State Significant Development Application – SSD 9694, 301 and 305 Kent  
Street, and 35–39 Erskine Street, Sydney

# Response to Submissions Addendum

KENT STREET HOTEL | NORTH ELEVATION

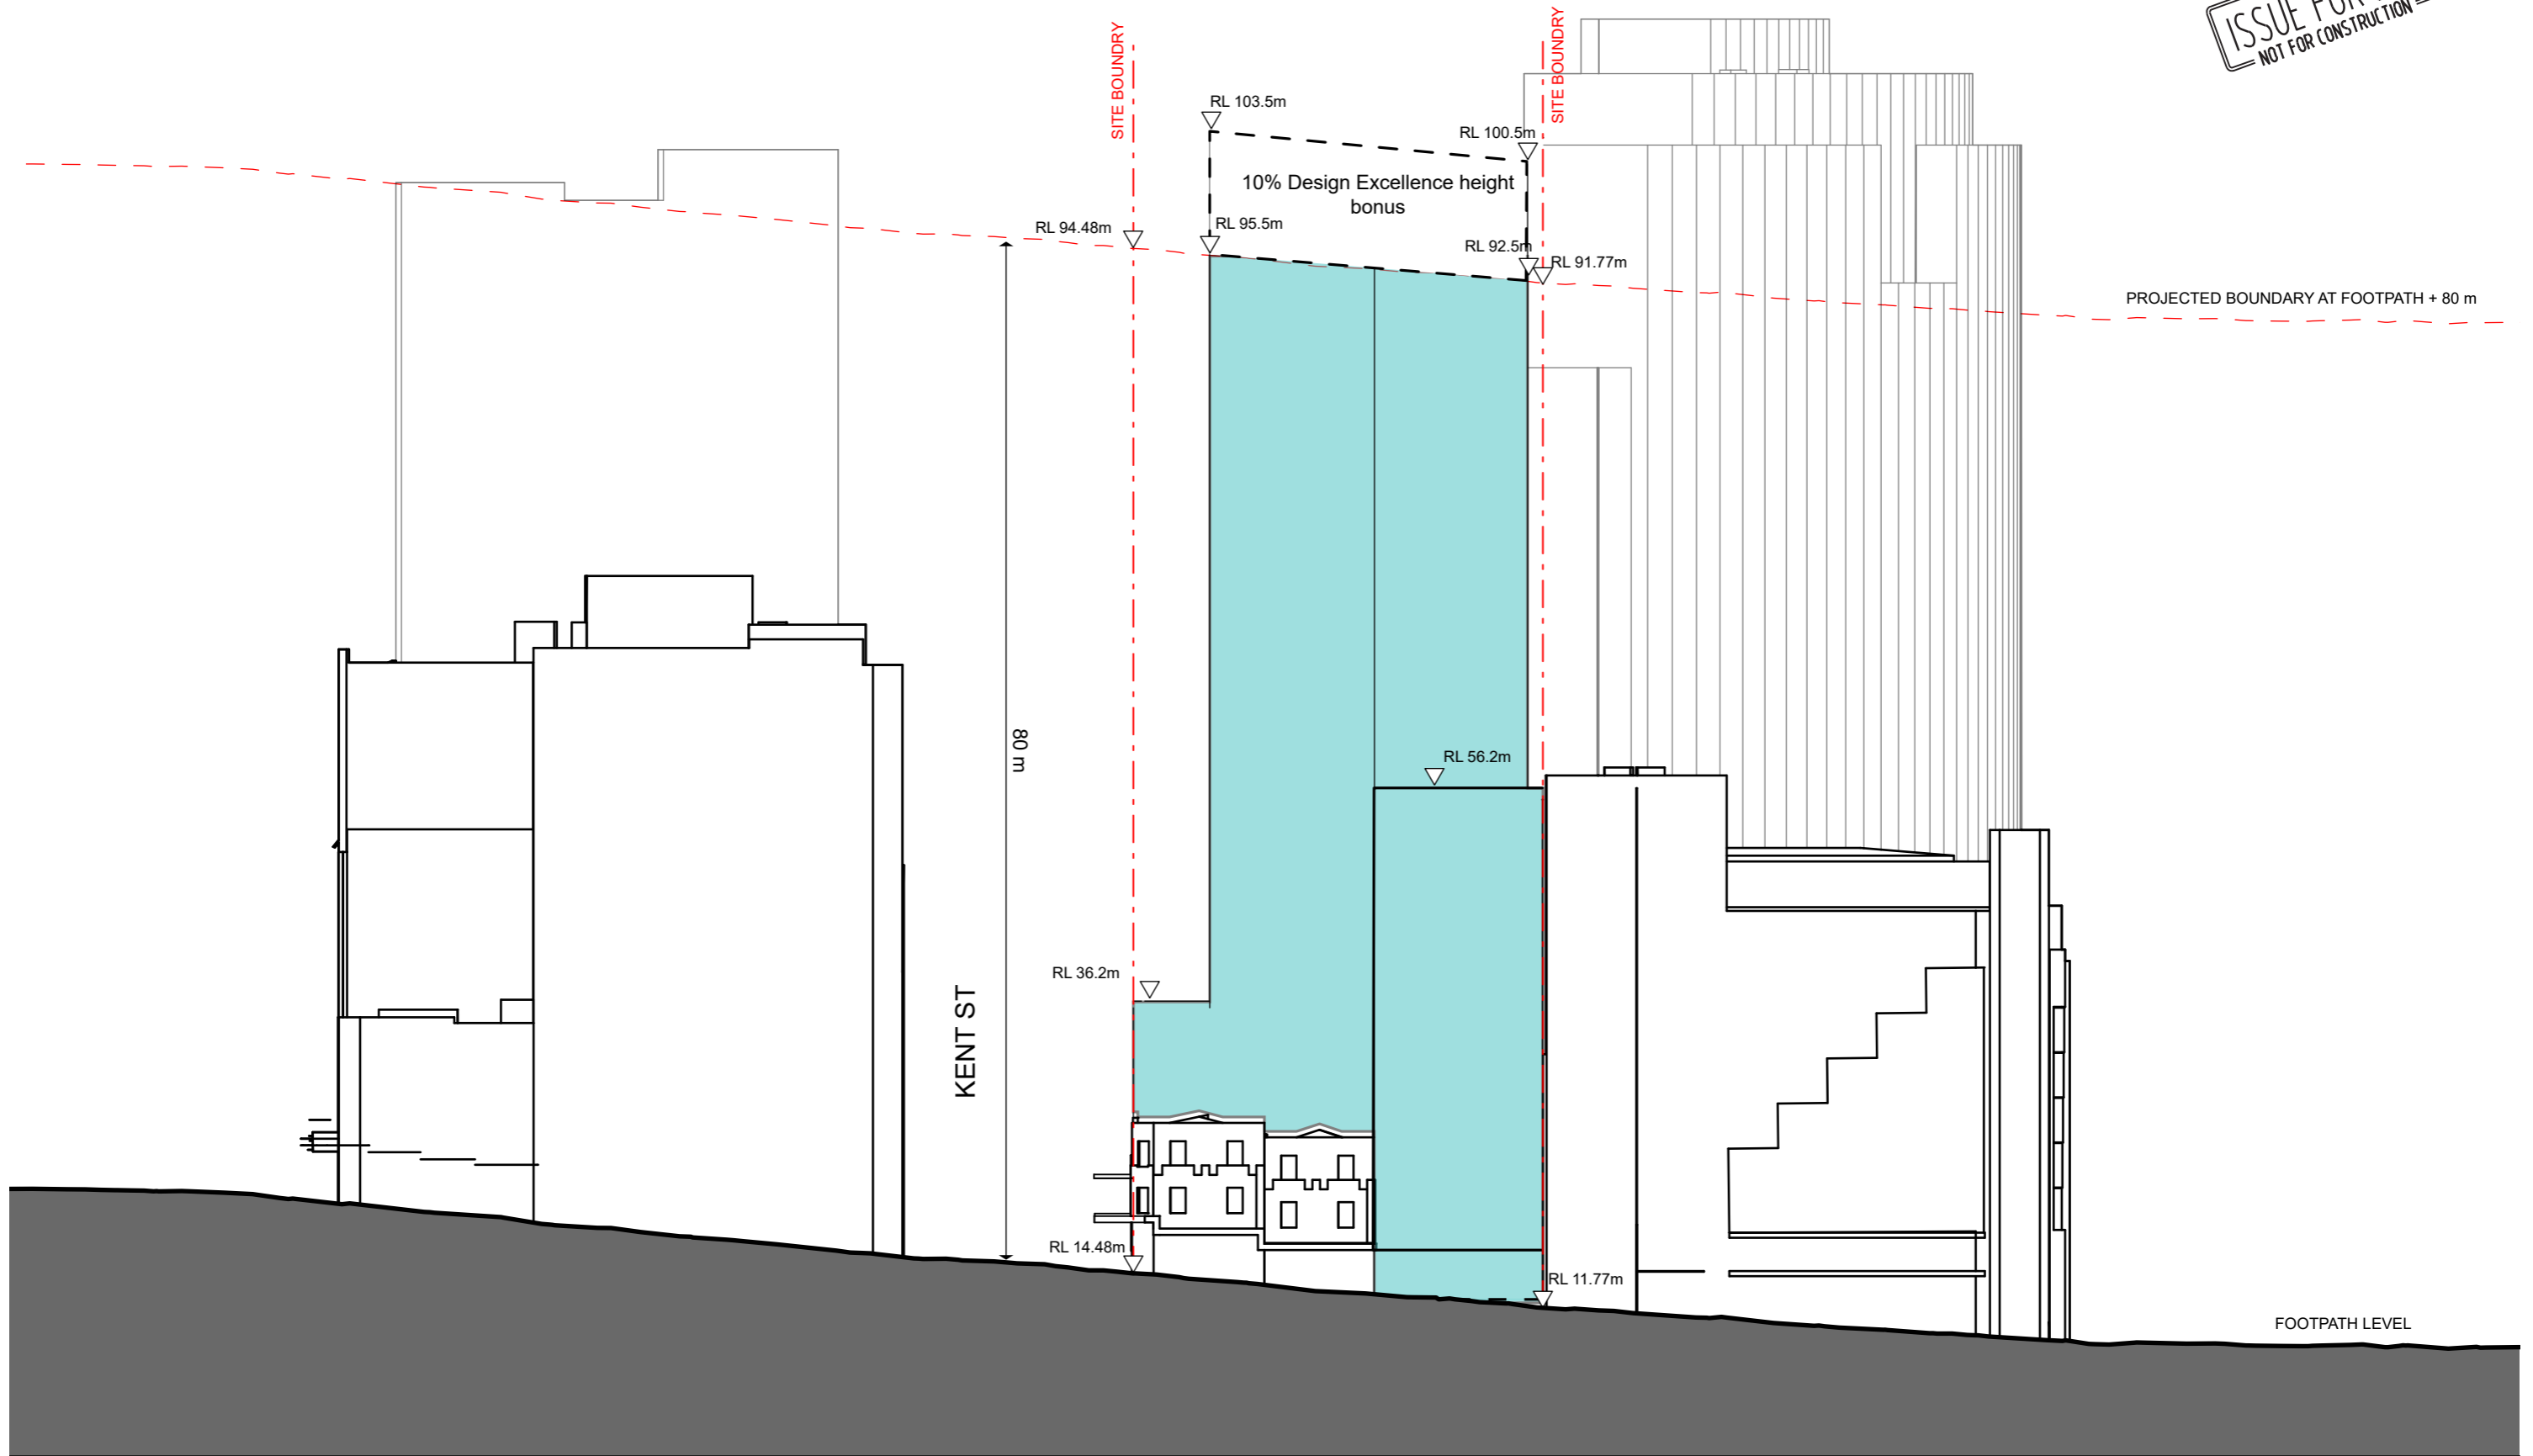
The City of Sydney Council's response to the response of submissions, provided that the Council did not support the 5.6% variation to the height control. They requested the building envelope drawings are to be amended to reflect the 80m height limit that aligns with the topographical fall of the site.

The Clause 4.6 variation to Building Height development standard is withdrawn, and a Concept Envelope is proposed that complies with the maximum LEP building height control of 80m. The highest point of the proposed Concept Envelope will be RL 95.9m on the south-east elevation.

Additional building height or FSR of up to 10% shown on LEP building heights / FSR maps respectively, may be sought in a future design competition, where it is demonstrated the design exhibits design excellence. This would then be confirmed in a Stage 2 Detailed DA. The amended Concept Architectural plans show 10% height bonus.

# Tower - Above 40m Height

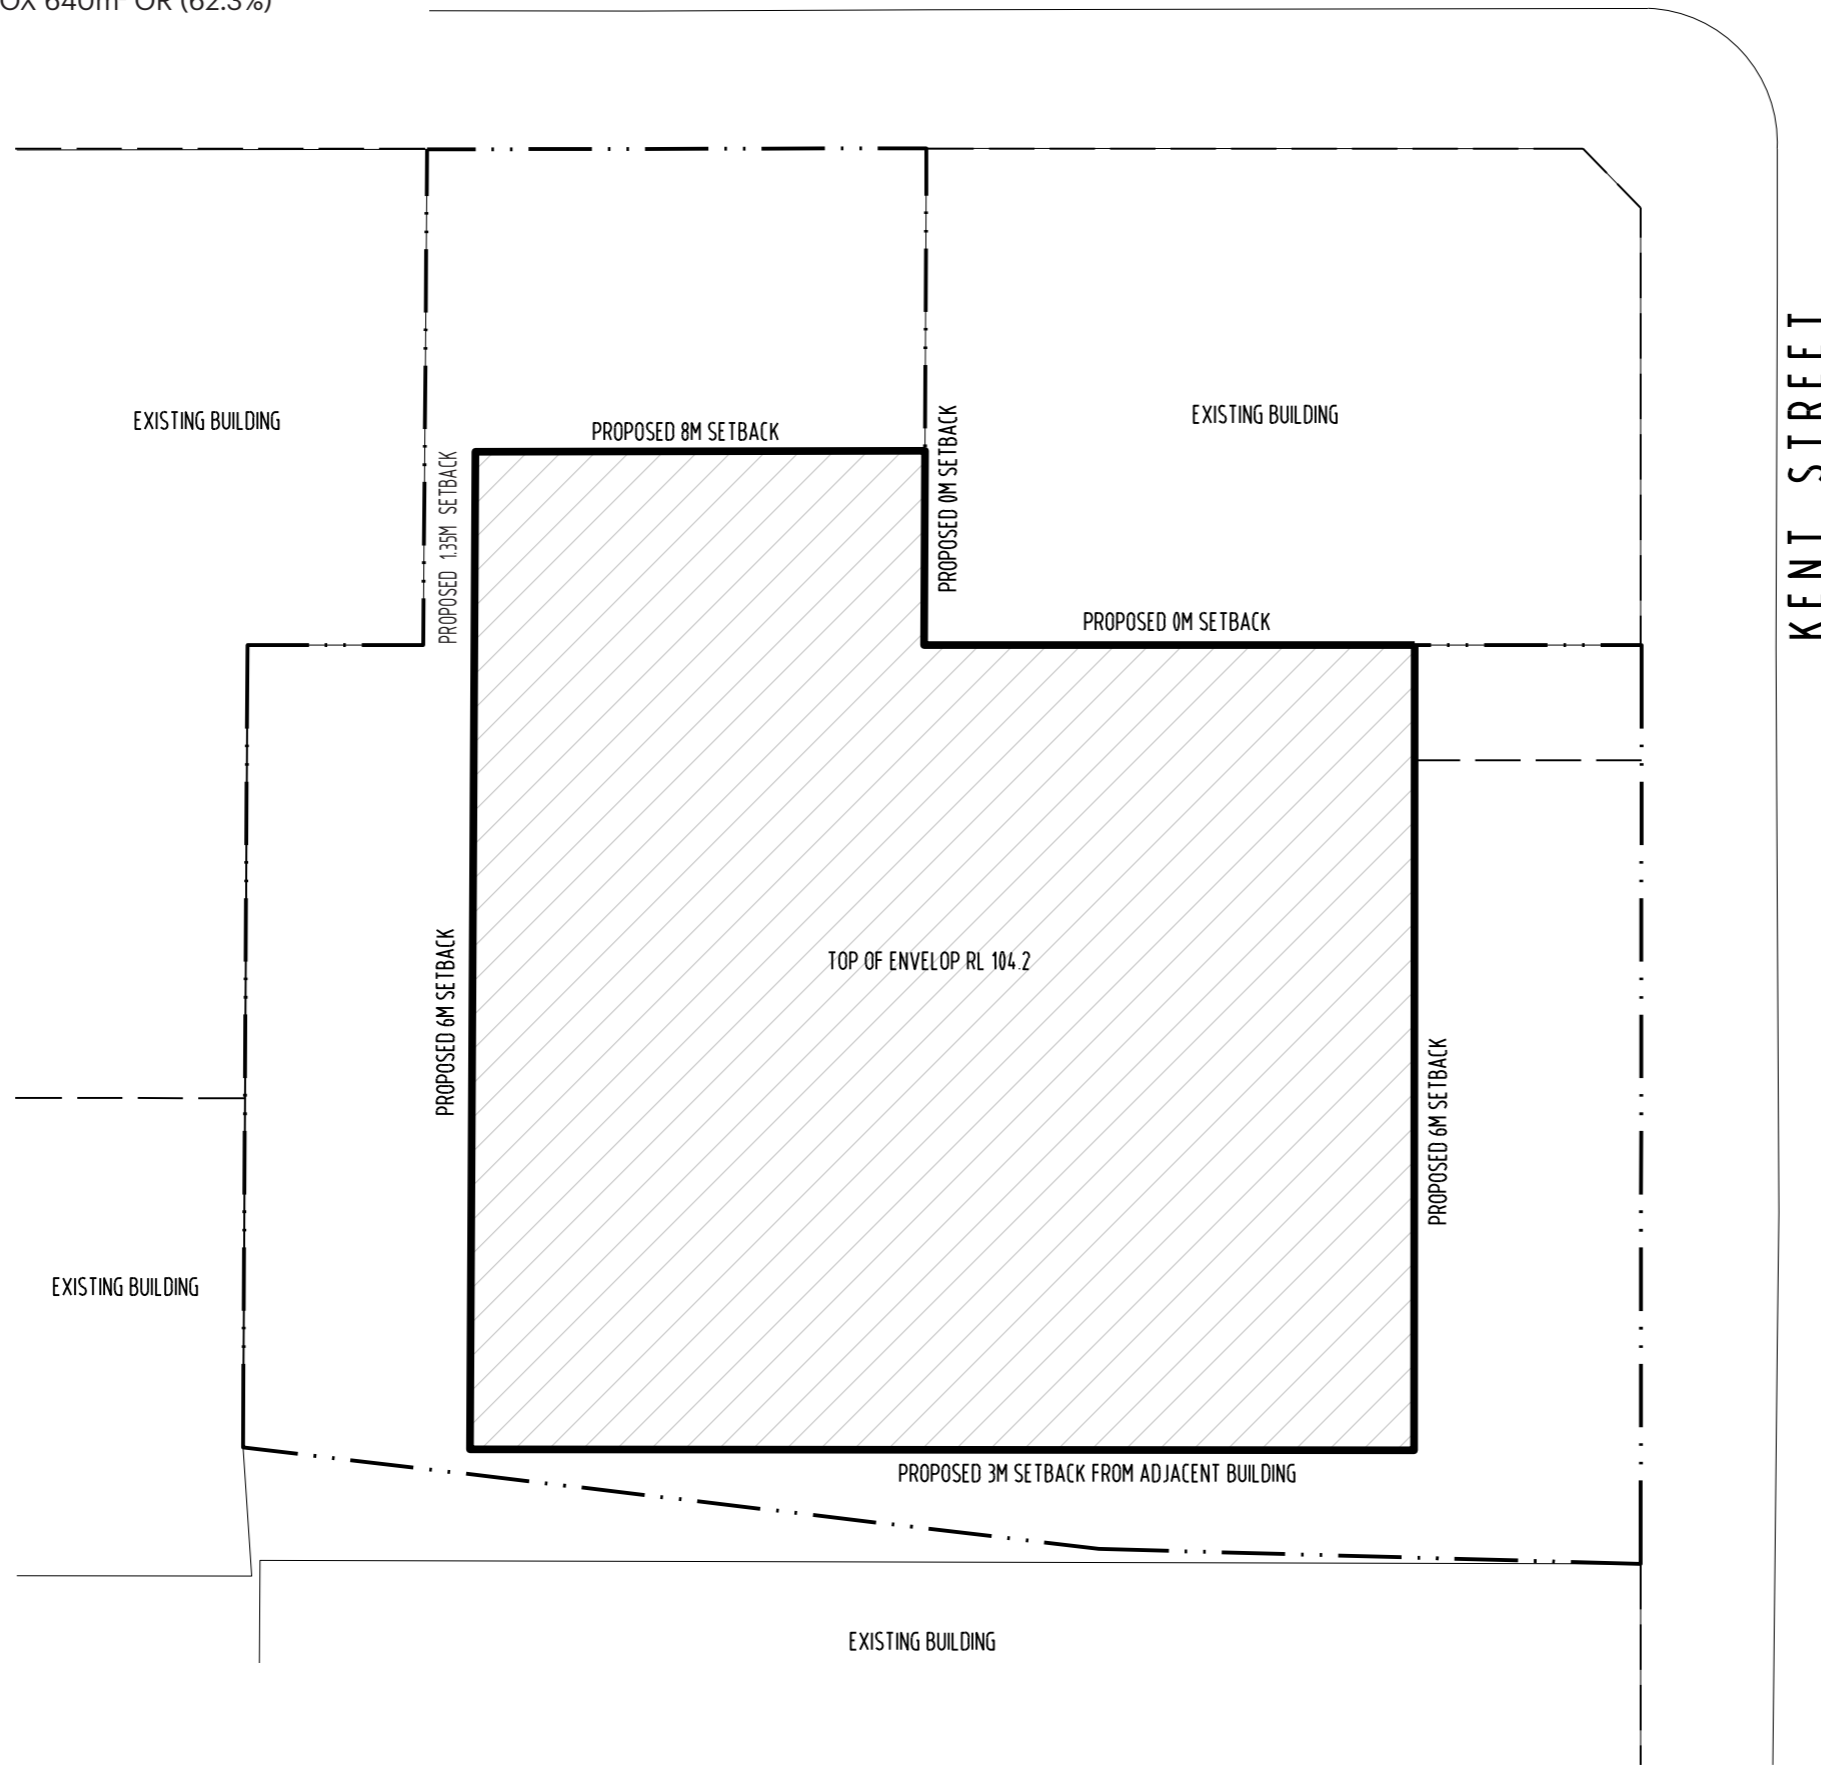
To the North, Council require an 8m setback to the building to alleviate wind impacts.

As noted in the submission, Council require a 3m setback.

To the south, Council submitted the southern setback requirement of 3m to the boundary, however this will result in bad planning outcomes. Due to the irregularity of the site and the angled side boundary, this proposal acknowledges Council's submission however requests the 3m setback to the adjoining building.

This setback has been amended in accordance with Council's requirement, and is shown in the amended building envelope drawings at **Appendix A**.

Despite the above, the plans have been updated to allow a 1.35m setback to the adjoining western building, to accommodate for potential redevelopment if future development were to occur at 35-39 Erskine Street.

The 3m setback to the adjoining building will allow for regular built form and for the site to be parallel with the Dexus building at 209 Kent Street. The proposal provides a setback compliant with Section 5.1.2.2, subclause (3) of the Sydney DCP, mentioned above, which allows a nil setback for commercial buildings with no windows. Further, the submission from Dexus also notes that the setback to the south is compliant.
